**Consultation Response from KC, Highways Development Management (HDM)**

**2022/92471 Heckmondwike Hub Bus Station, Royle Fold, Heckmondwike, WF16 0HW**

**Redevelopment of Heckmondwike Bus Station including a new concourse building with waiting room, Changing Places WC, driver offices, 6 No. bus stands, landscaping, and associated works**

**RECOMMENDATION: Further information required**

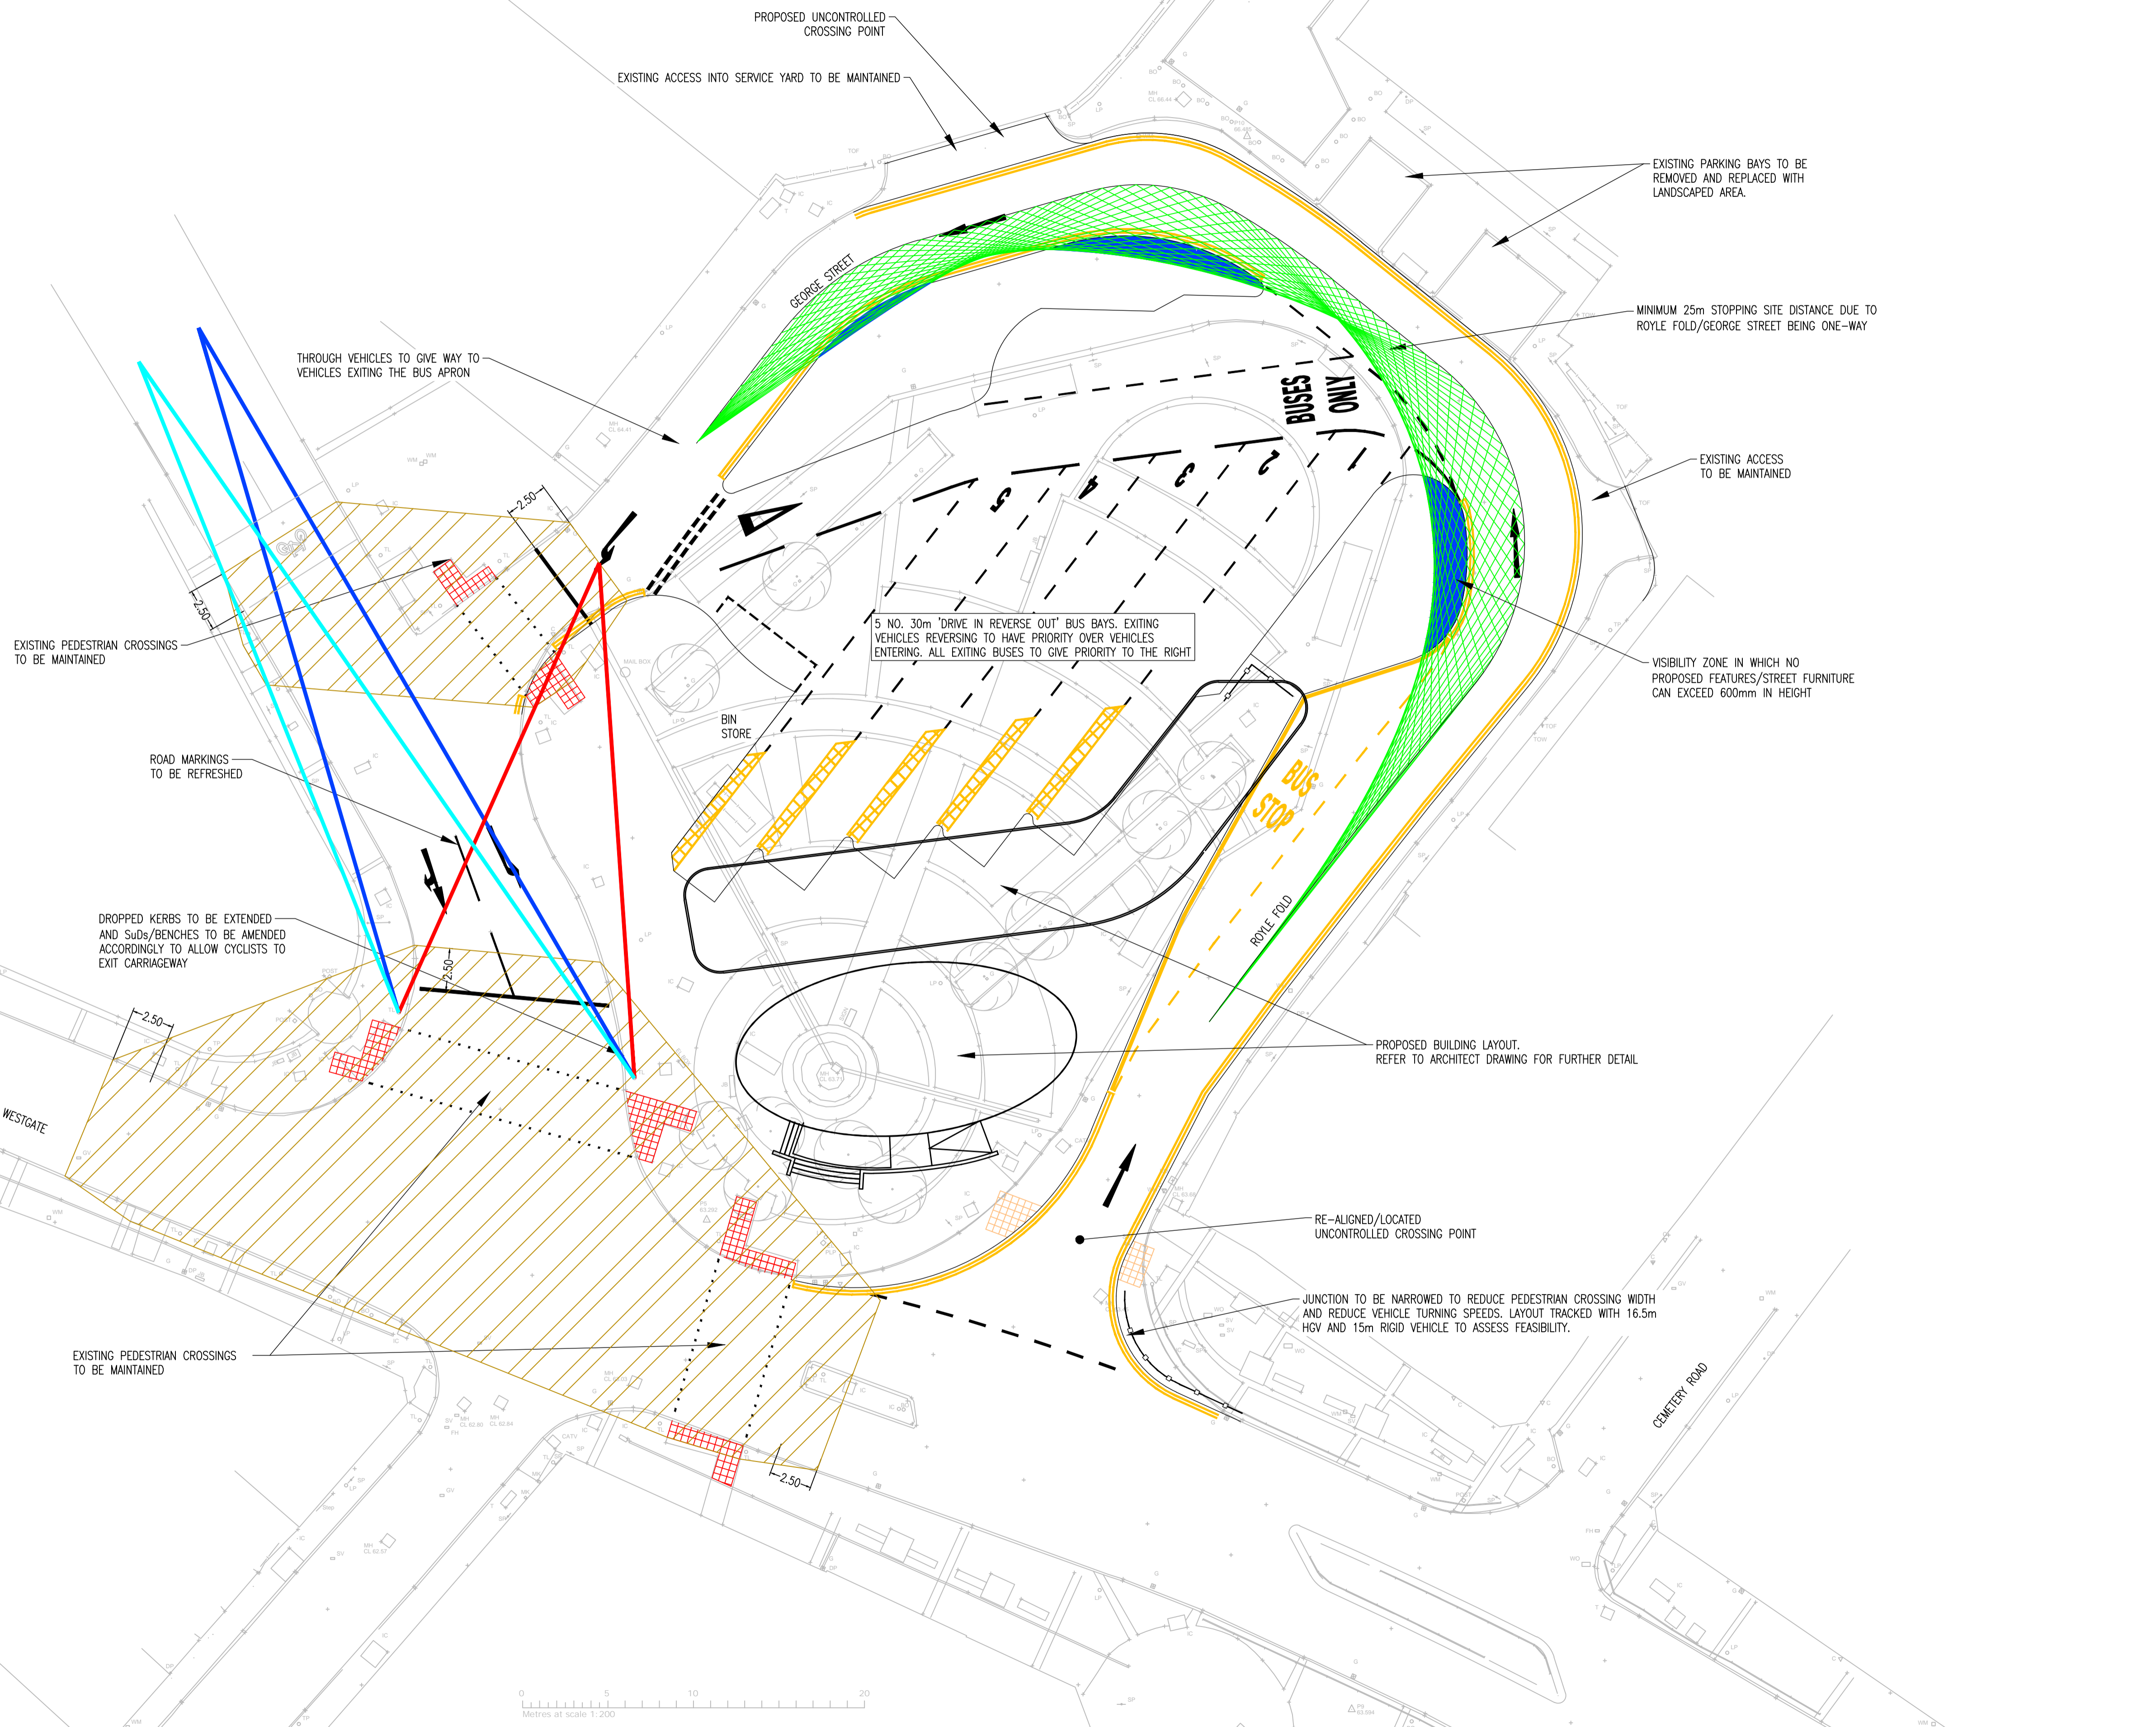
The proposed highway boundary must include all necessary visibility splays and sight lines that are required to allow the highway to operate safely and efficiently. Whilst a plan has been included in Appendix D of the Transport Assessment showing some of the visibility requirements, not all of the necessary splays/sight lines have been shown, and some have been shown incorrectly. Therefore, an updated visibility plan should be provided, and this should inform the revised highway boundary plan. For information, the following visibility splays/sight-lines need to be identified and accommodated:

- Junction visibility splay to the right from the bus station exit, with a set-back distance of 2.4m and based on the 20mph speed limit;
- Junction visibility at the private accesses on to George Street and Royle Fold;
- Forward visibility around the full perimeter of the site on Royle Fold and George Street based on the 20mph speed limit. It is noted that this has been partially shown on the drawing in Appendix D, measured from the centre of the carriageway. However, this needs to be amended to take account of drivers who would be travelling closer to the nearside kerb (e.g. from an offset of between 1.5 - 2.0m from the nearside kerb edge), such as cyclists.
- Forward visibility to the stop lines and traffic signals, including the George Street approach;
- Junction inter-visibility zone(s) at the adjacent traffic signals.

It is noted that a number of the above visibility splays/sight-lines are likely to impact on various street furniture and street trees that have been proposed, which will need to be reviewed and potentially relocated once the additional visibility information has been provided.
